CITY OF ALBUQUERQUE

**Planning Department
Transportation Development Services Section**

Re: **Certification for Permanent Building Certificate of Occupancy (C.O.)**
Lowes Parcels (Los Angeles Center, Tract A-1B-1-B & A-1-B-1-C), [D-18/D014D]
6230 Paseo del Norte
Architect's Stamp Dated 01/10/13

RE: Los Angeles Center (Lowes' out-parcels), Tracts A-1-B-1-B & A-1-B-1-C
Grading and Drainage Plan for Grading, Paving and Building Permit
SW Corner of Paseo del Norte & San Pedro PE Stamp: 7/11/12 (D18-D014D)

ENGINEER'S SEAL	LOS ANGELES CENTER	DRAWN BY WCWJ
	GRADING AND DRAINAGE PLAN	DATE 5-15-12
	 <i>Rio Grande Engineering</i> 1606 CENTRAL AVENUE SE SUITE 201 ALBUQUERQUE, NM 87106 (505) 872-0999	21204-LAYOUT-3-28-12
		SHEET # —
DAVID SOULE P.E. #14522		JOB # 21204

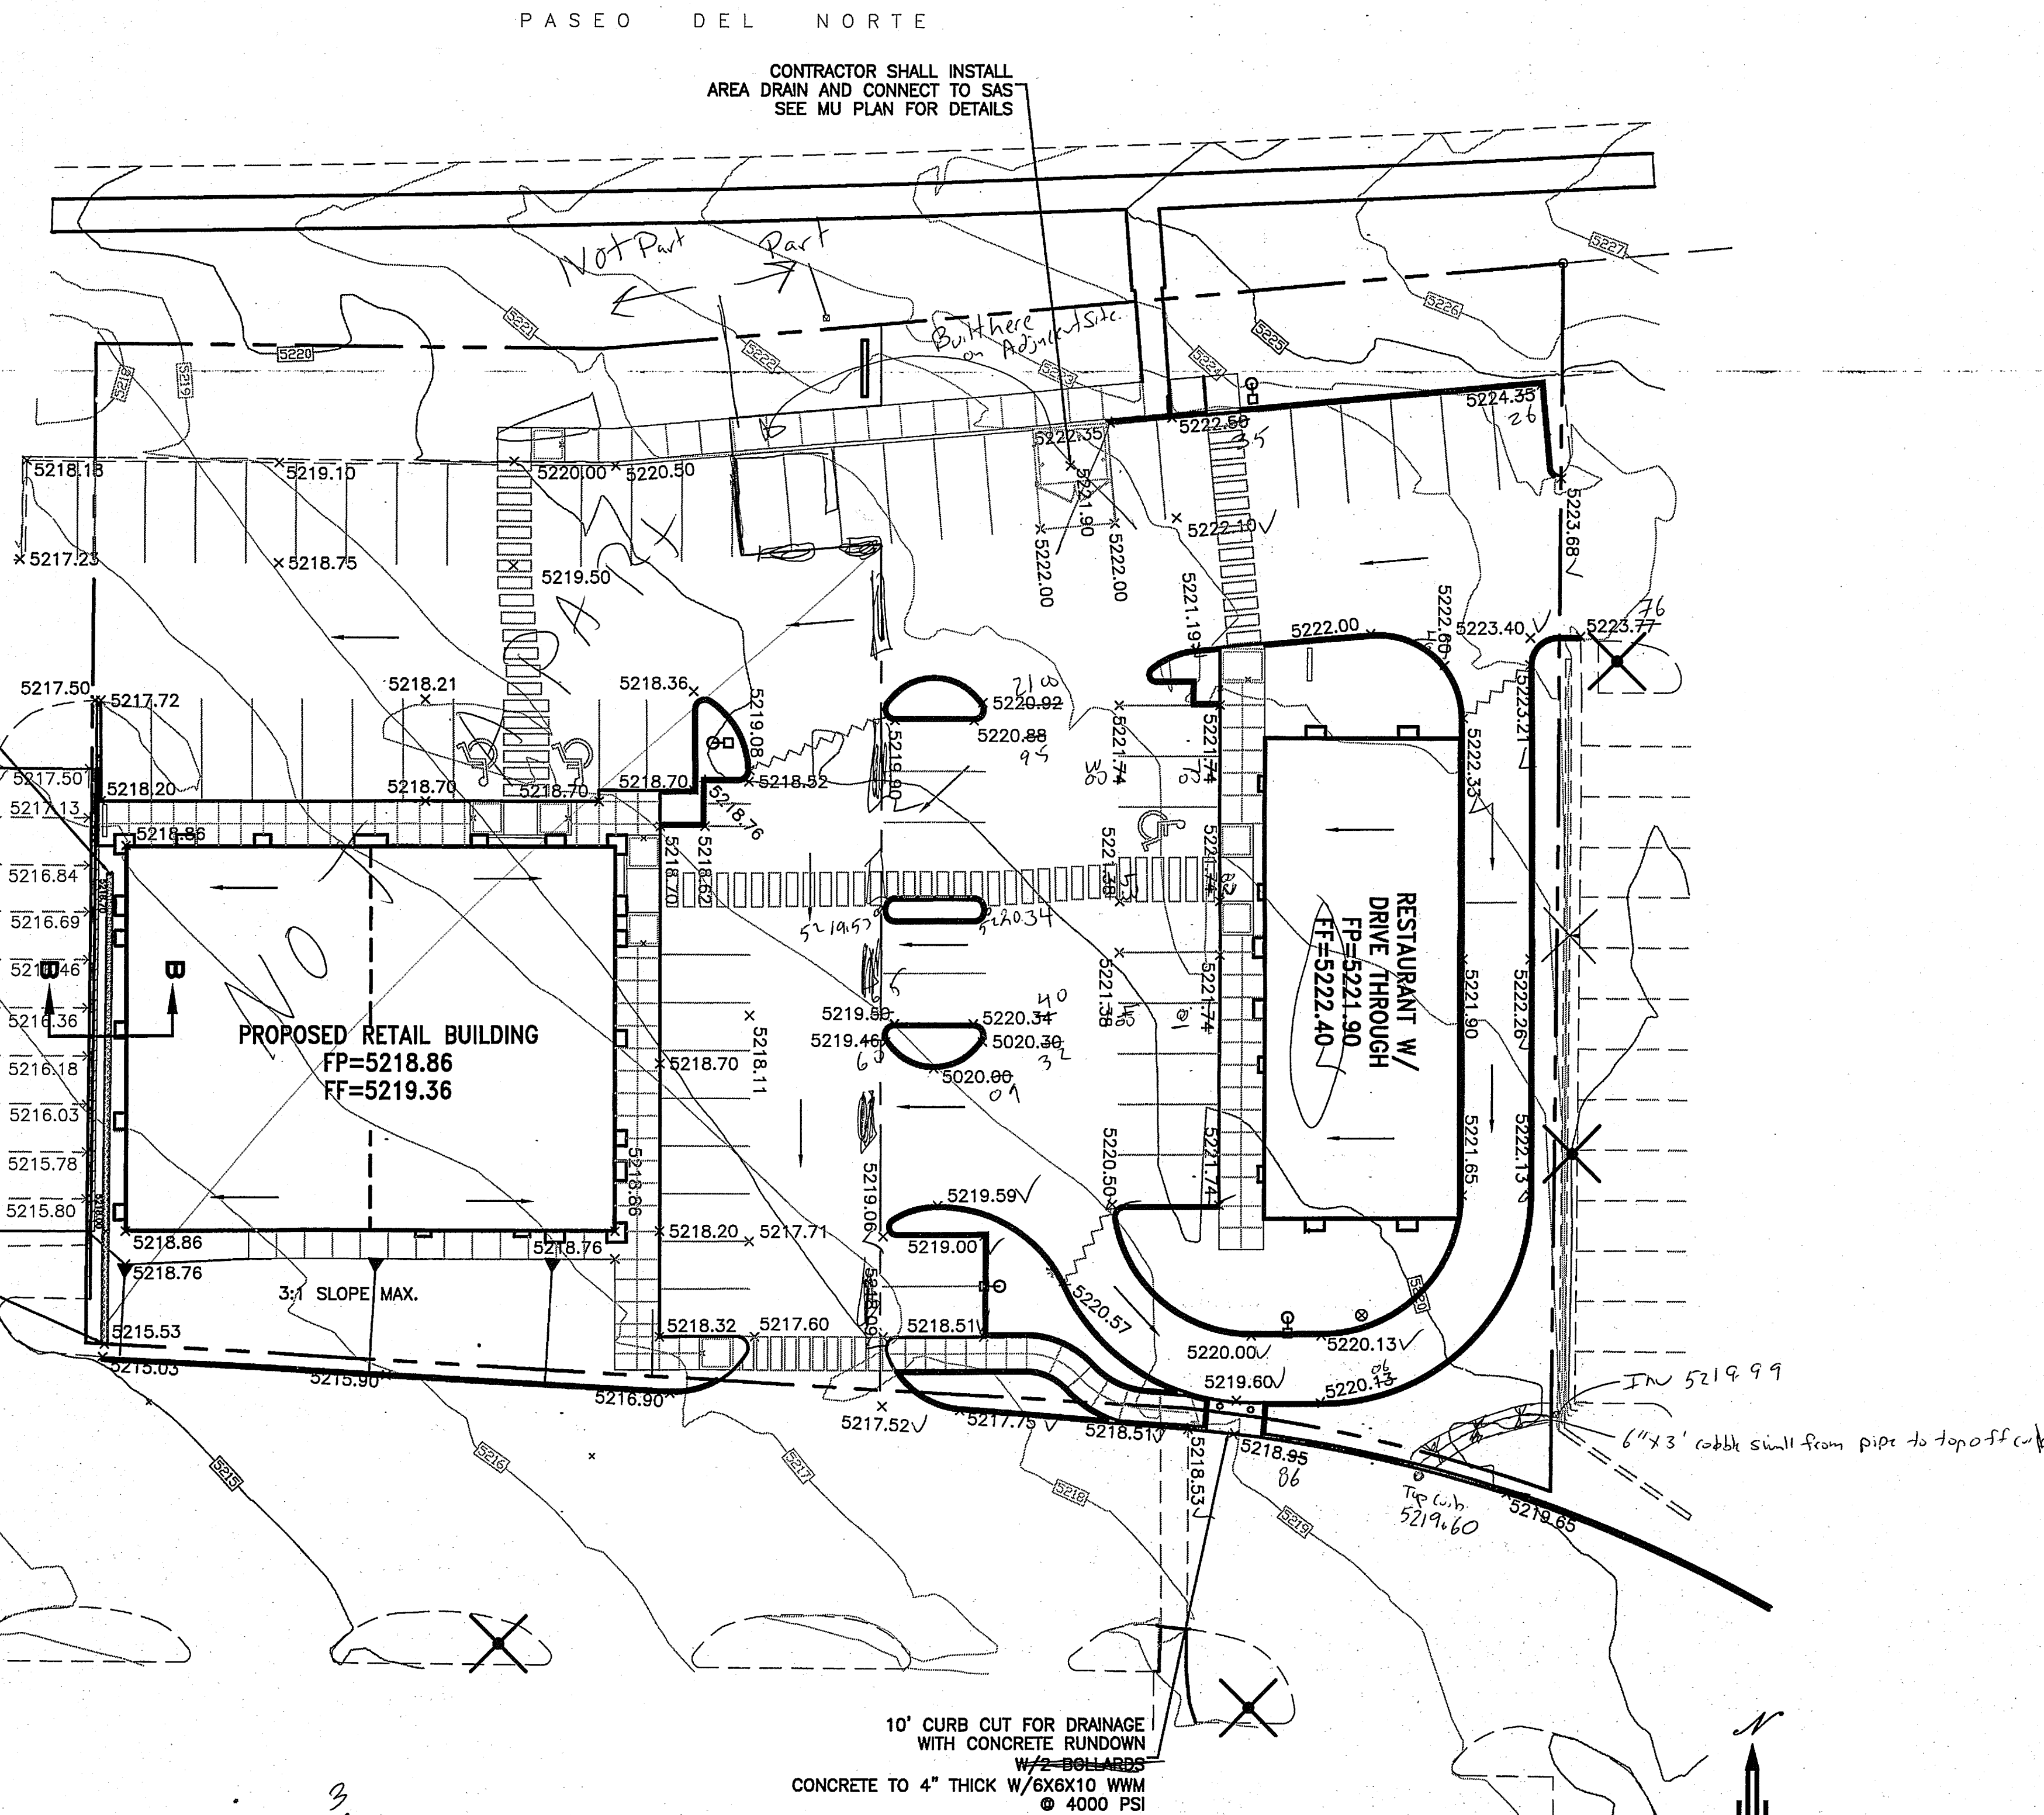
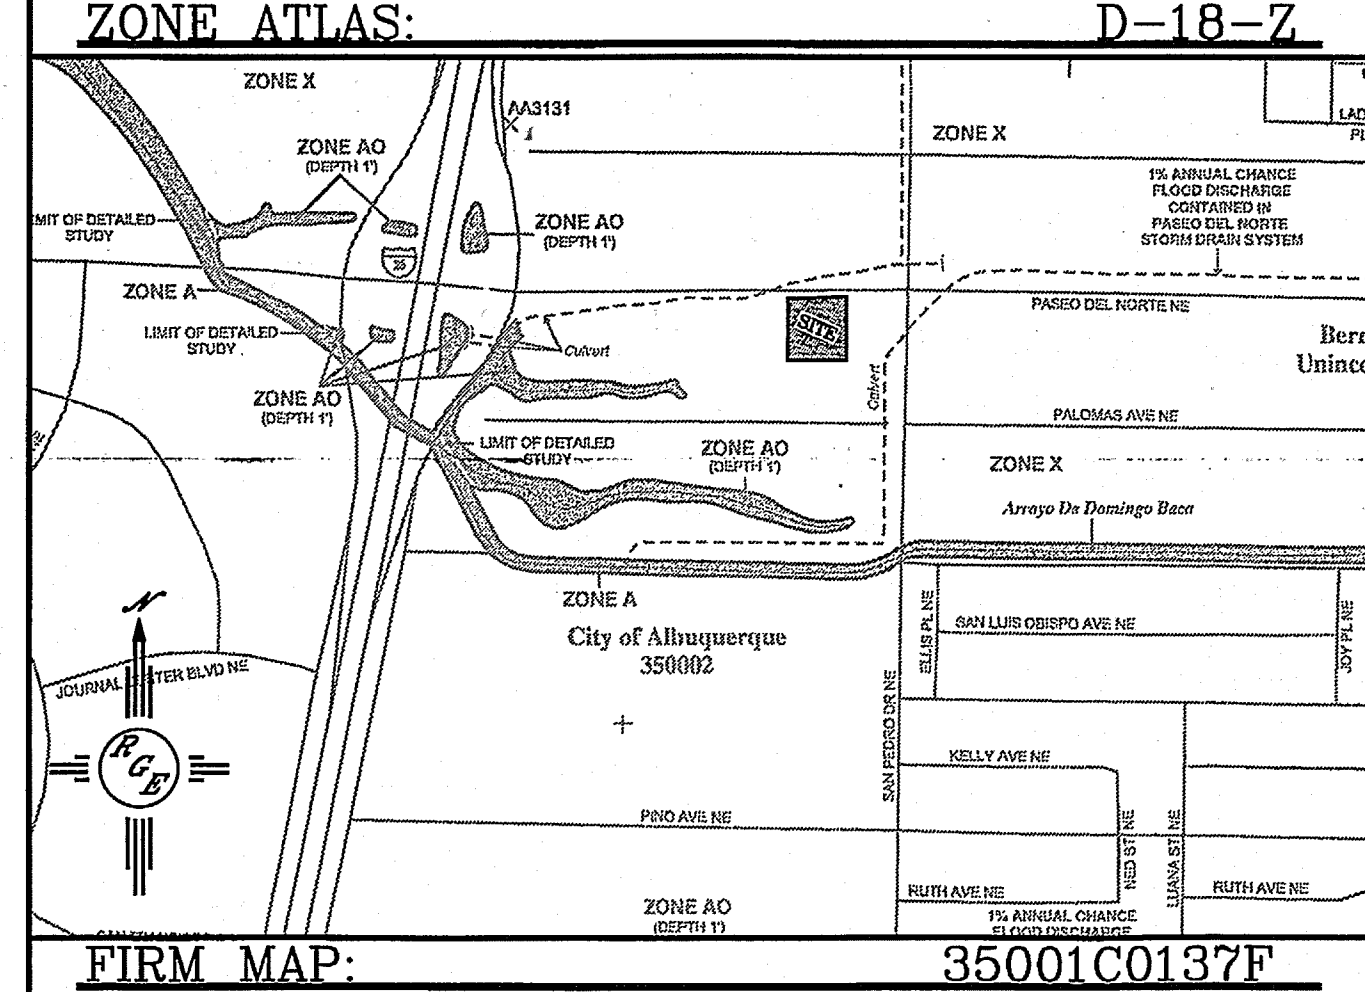
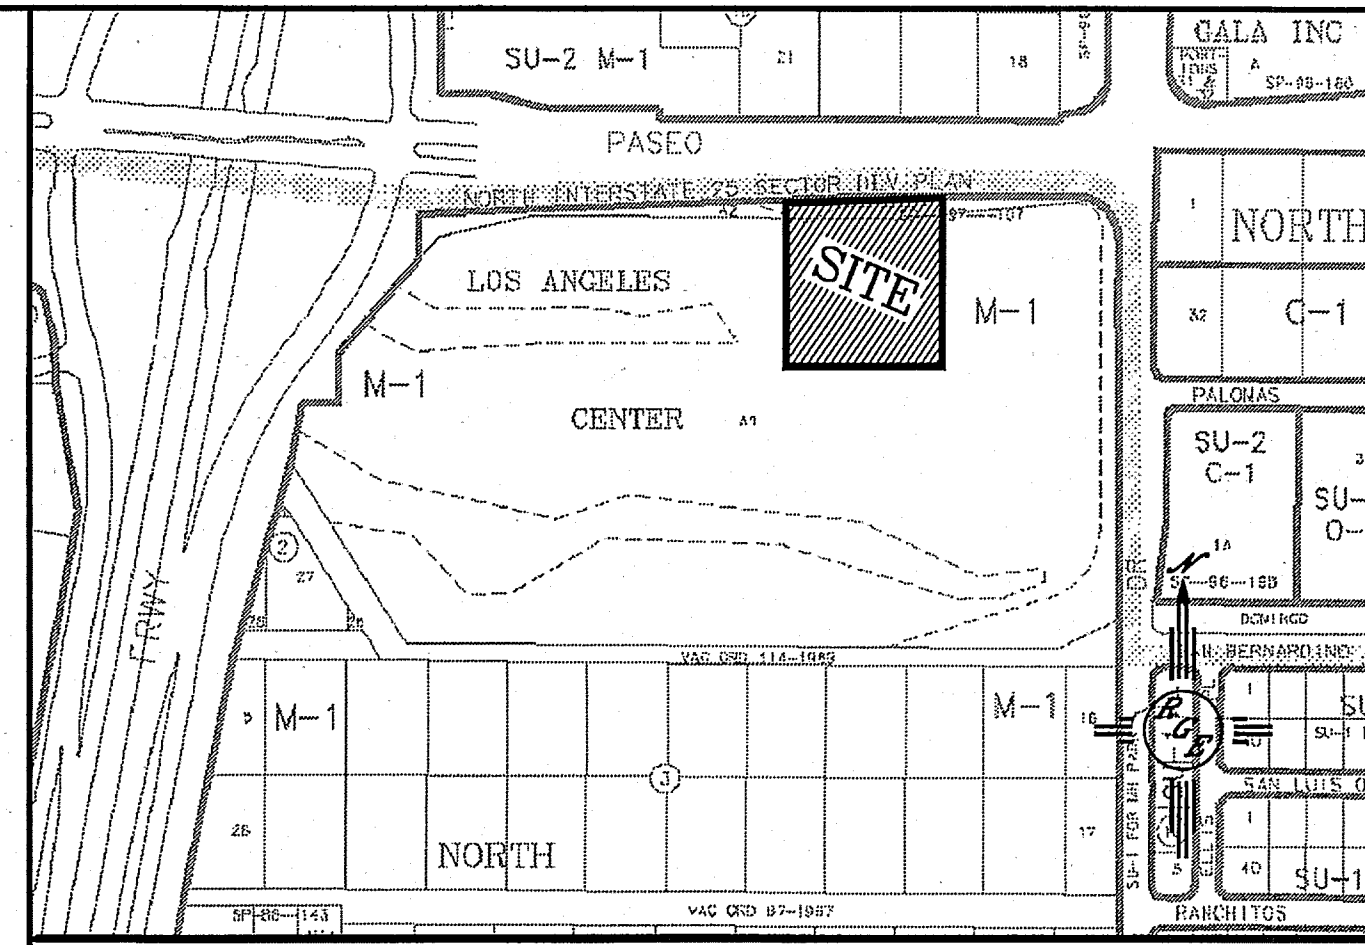
1. **Where does roof runoff go from SW building?** Avoid erosion on the steep side slopes S & W of pad. - added a cobble swale and place note that roof drains shall connect to cobble swale on west side. south side has no roof flow but added note for larger angular rock landscaping.

a. at 10' wide will it become a shortcut to the drive-through? - put bollard in middle
